From: Anita Gardner
Sent: 28 February 2018 15:55
To: Planning.Responses
Subject: FW: Planning Consultation on: AB/149/17/L

APPLICATION AB/149/17/L

Site Address: 44 Tarrant Street Arundel BN18 9DN

Description of Works: Listed building consent for internal alterations & renovations

Drawing Name
Heating & Electrical 1/2

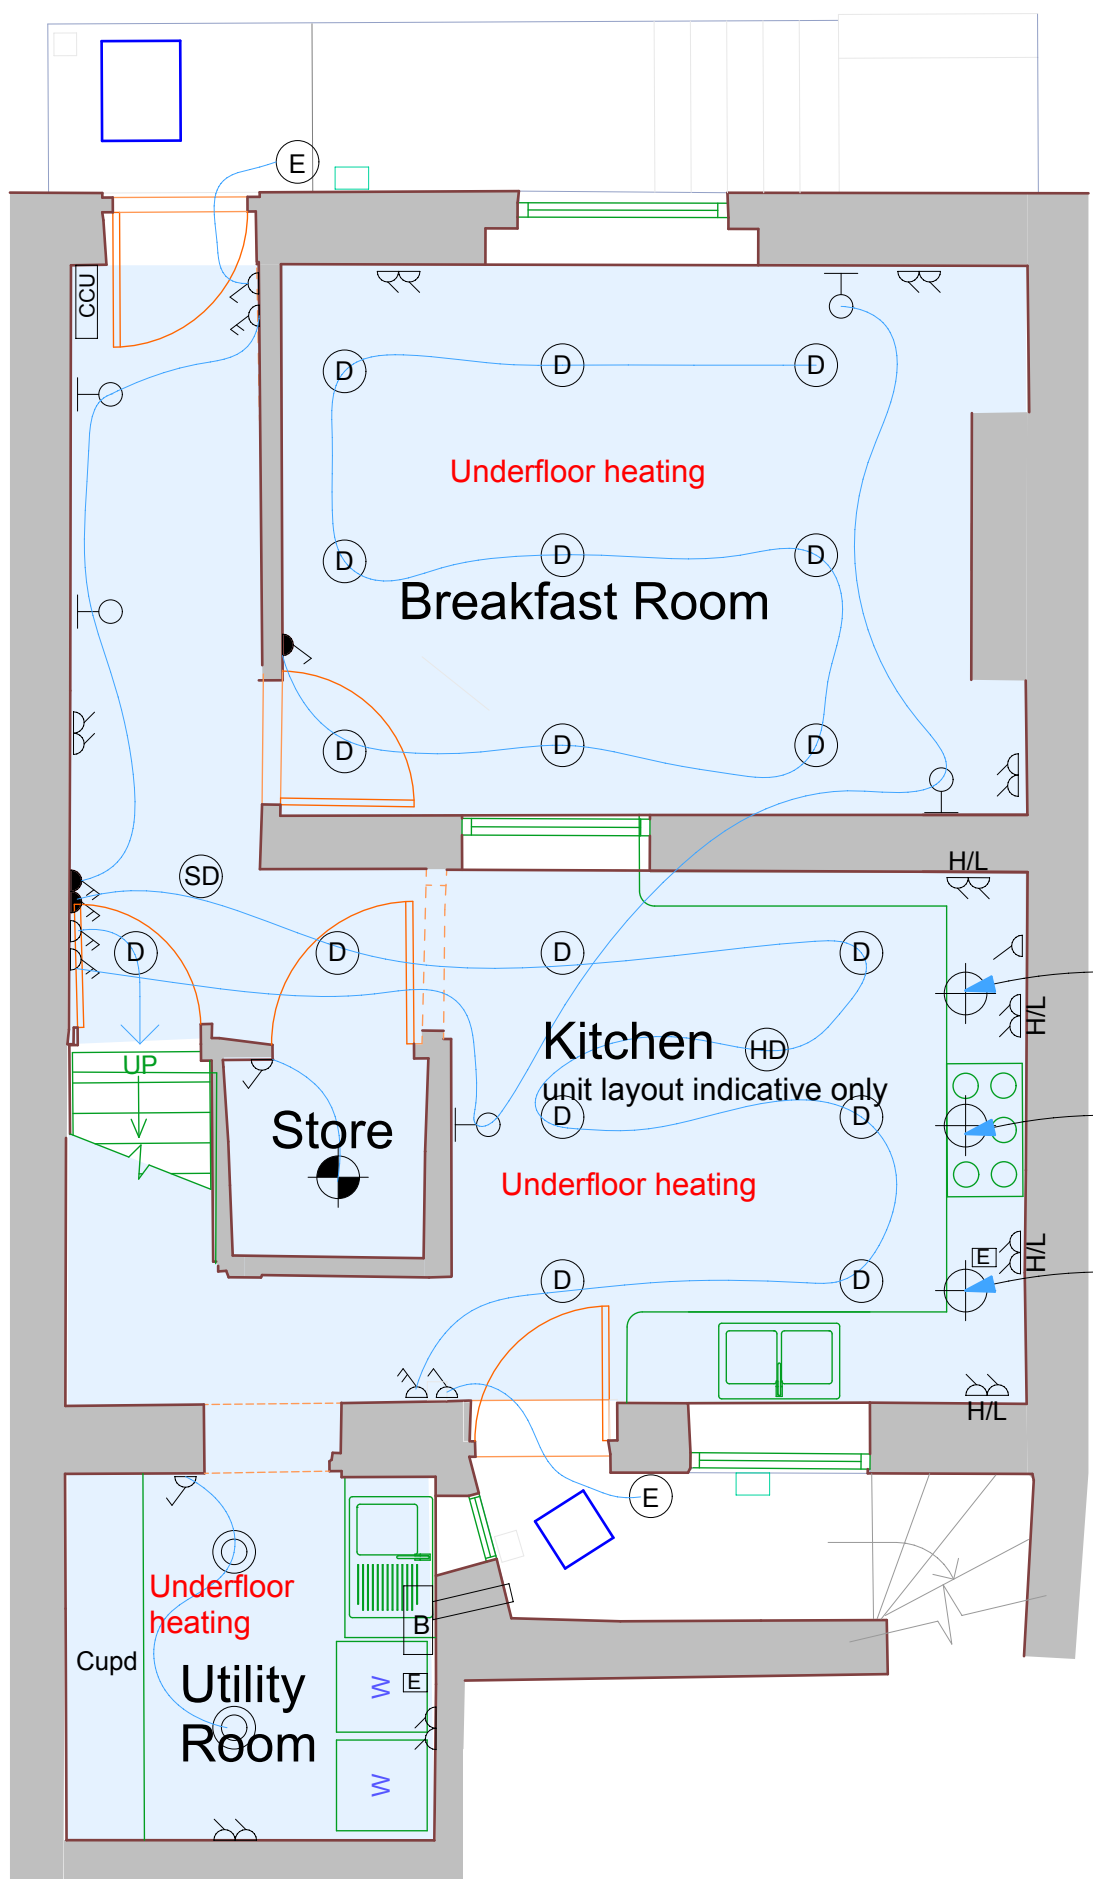
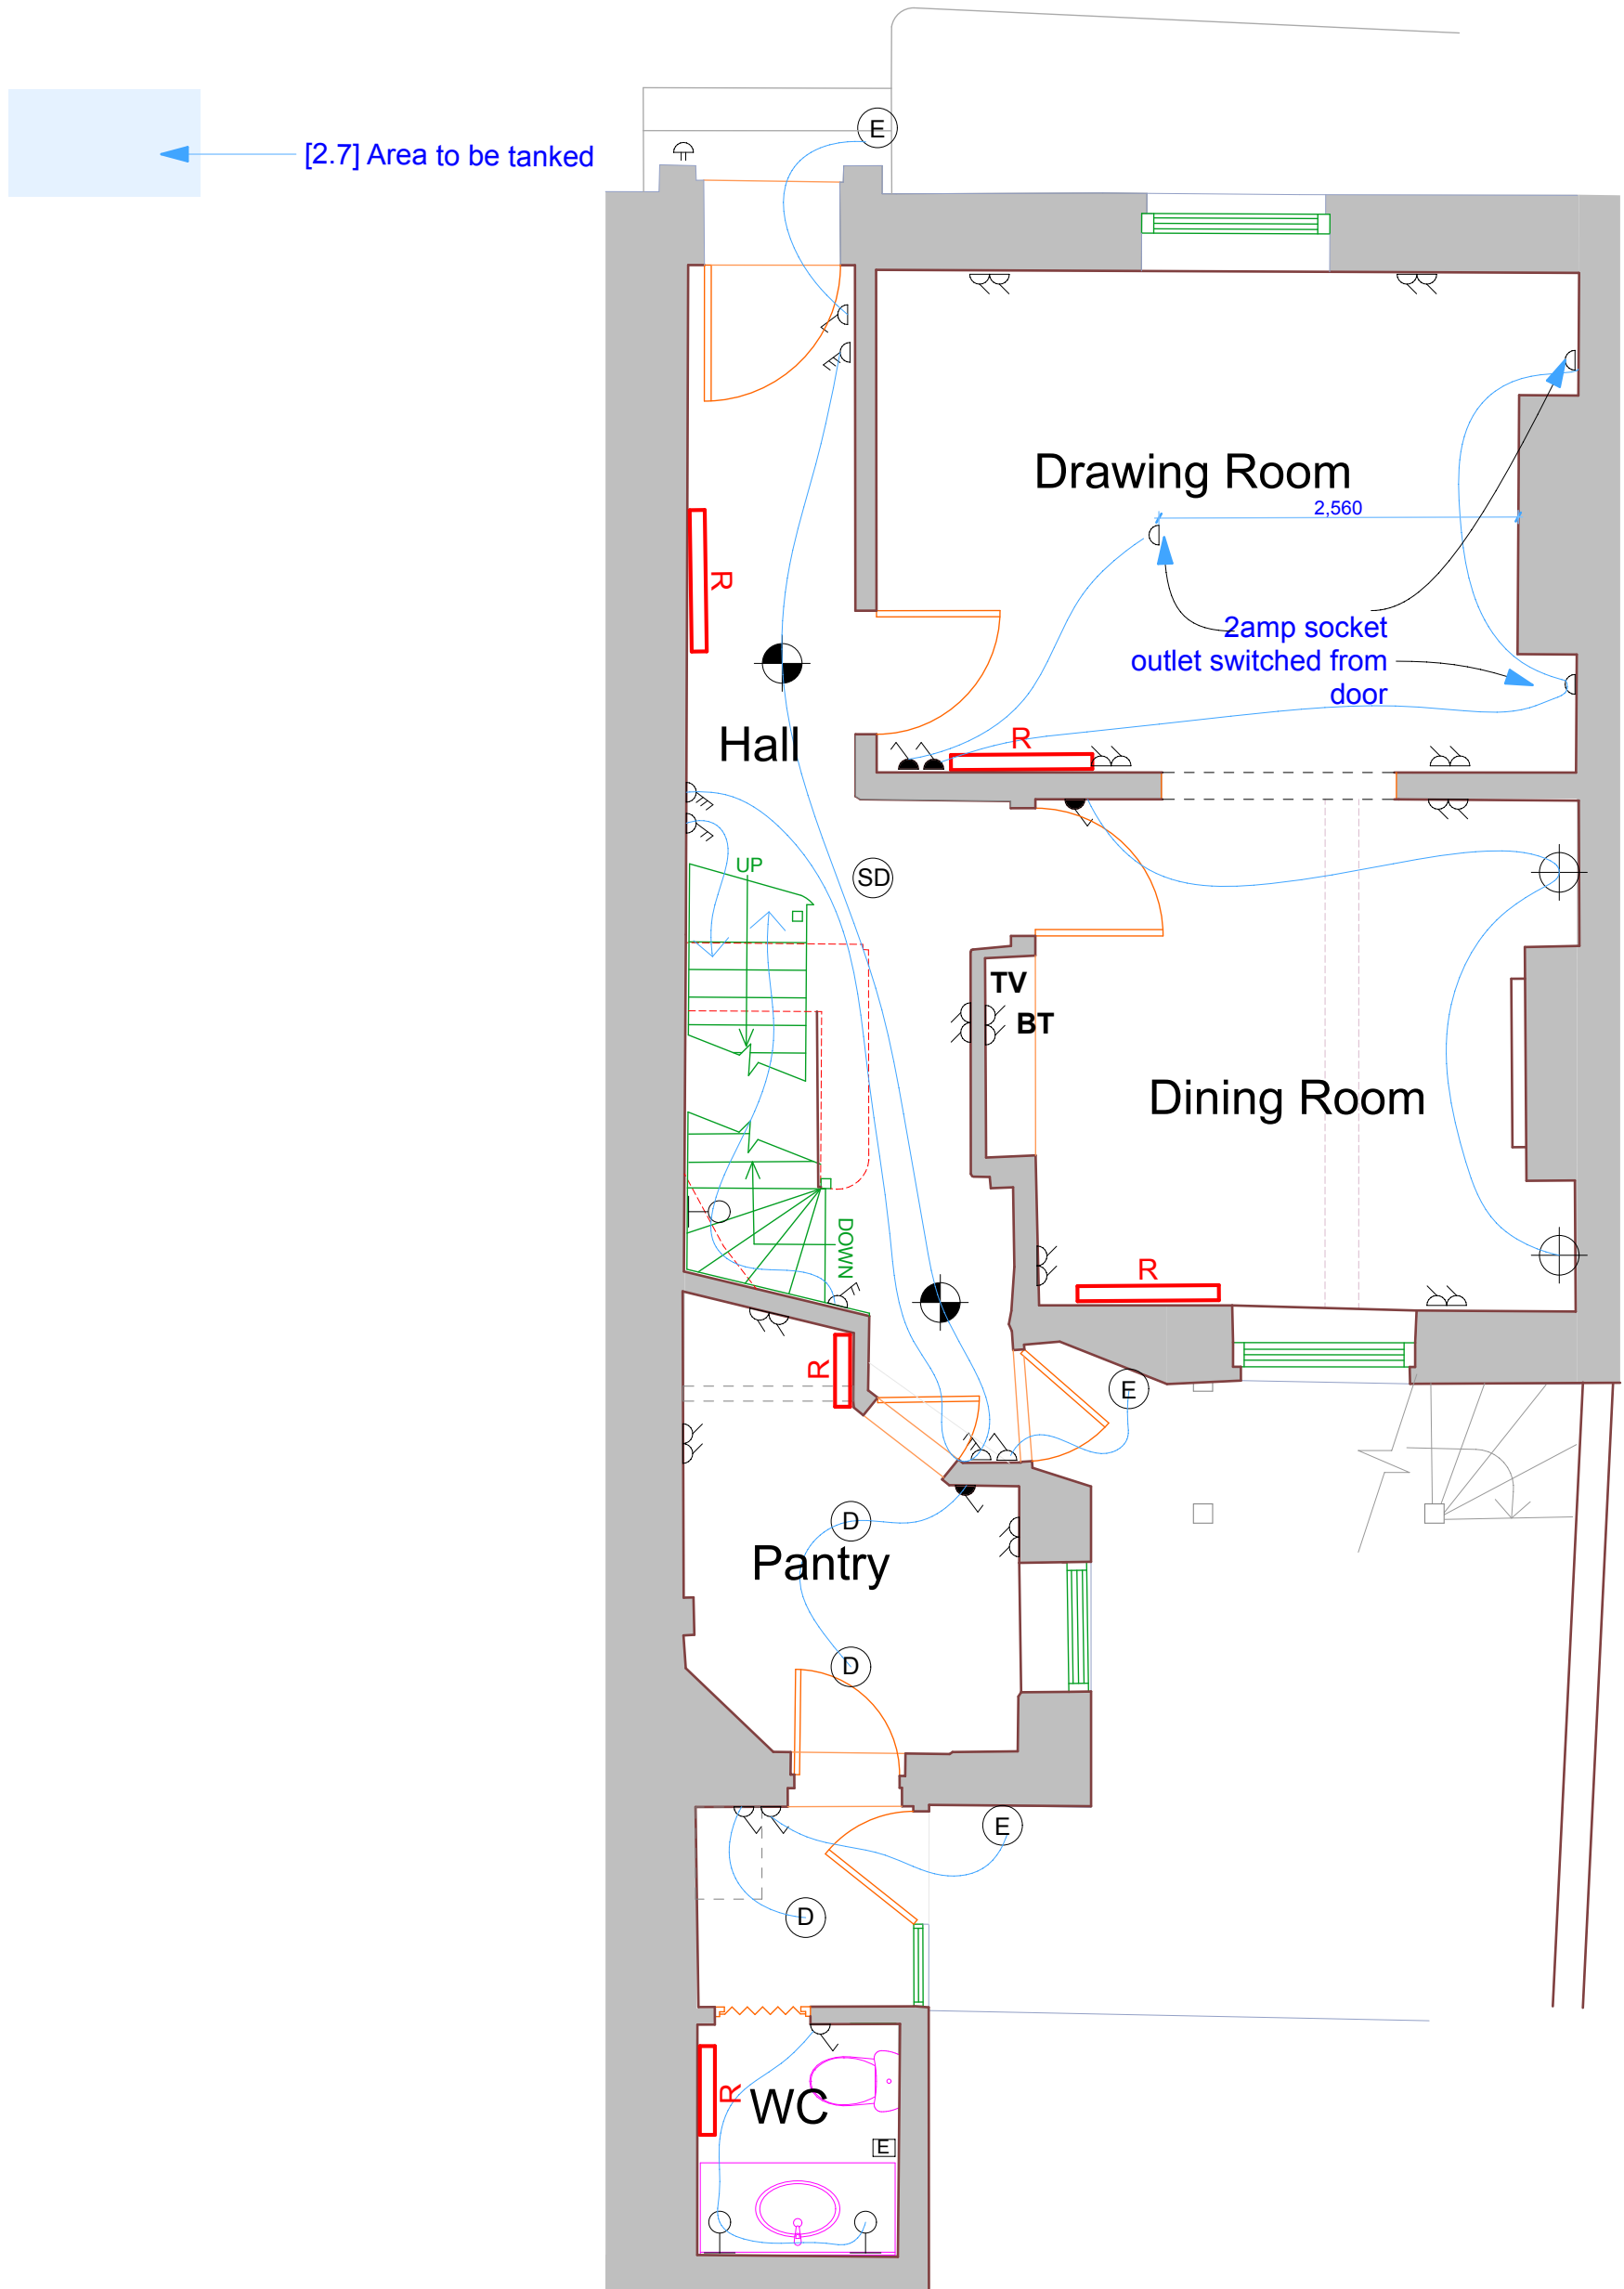
- The installation of downlighters other than to 2ndFloor where dropped ceiling is evident. The introduction of these is disruptive to historic fabric.
